Ribble Valley Borough Council
Housing & Development Control

Application no: **3/2020/0597**

Address: **Rockdale Main Street Grindleton BB7 4QT**

Proposal: **Demolition of garage workshop and construction of new single storey extension to the rear and roof alterations.**

2 PROPOSED SITE PLAN
1 : 200

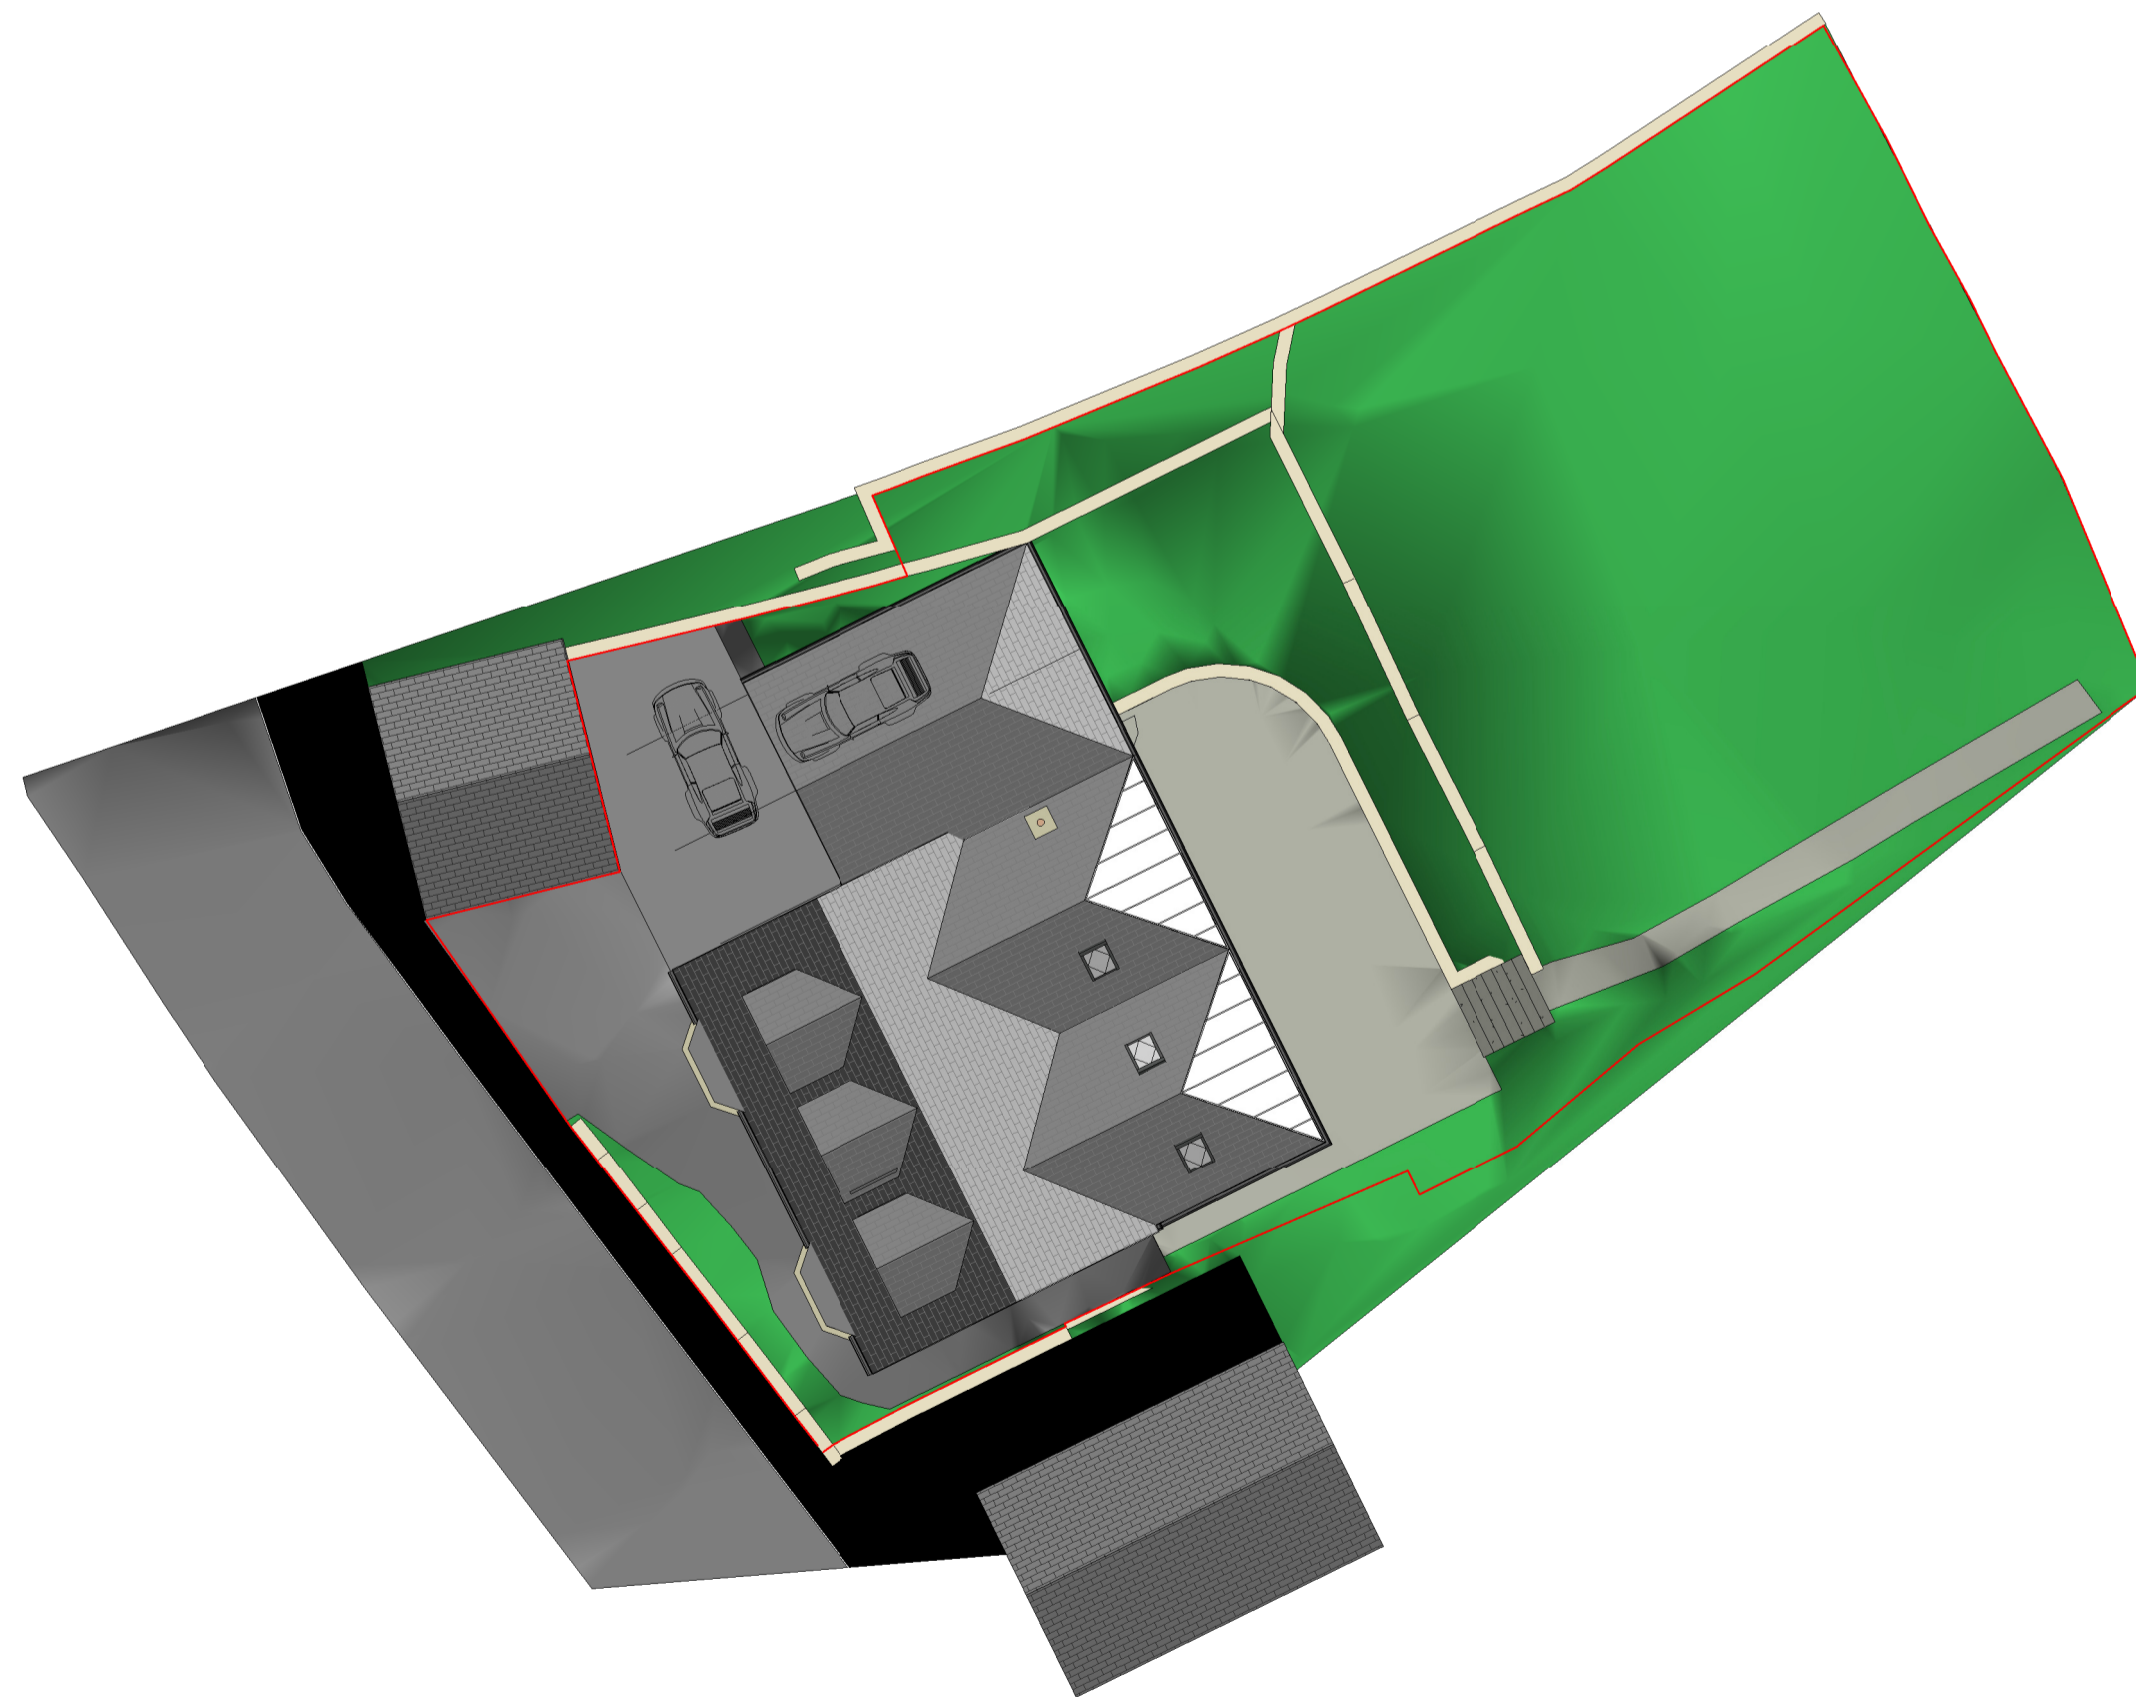
The proposed demolition of a garage along with the construction of a new single storey extension to the rear and roof alterations will result in the existing driveway being widened with the introduction of a carport to support the required parking provision of two parking spaces and due to the partial removal of the boundary wall fronting the dwelling, the Local Highway Authority must draw our attention towards the visibility splays required for vehicular access upon leaving the property and adjoining the local highway network, and therefore must ensure the applicant does not reconstruct the boundary wall or plant any shrubs, fences etc. within the visibility splay at a height no greater than 1.05m. Similarly the proposed driveway shall be bound with an approved surface material and an extension to the dropped crossing fronting the driveway will need to be carried out prior to the driveway becoming used for vehicular purposes.

2. Before the access is used for vehicular purposes, that part of the access extending from the highway boundary for a minimum distance of 5m into the site shall be appropriately paved in tarmacadam, concrete, block pavements, or other approved materials.
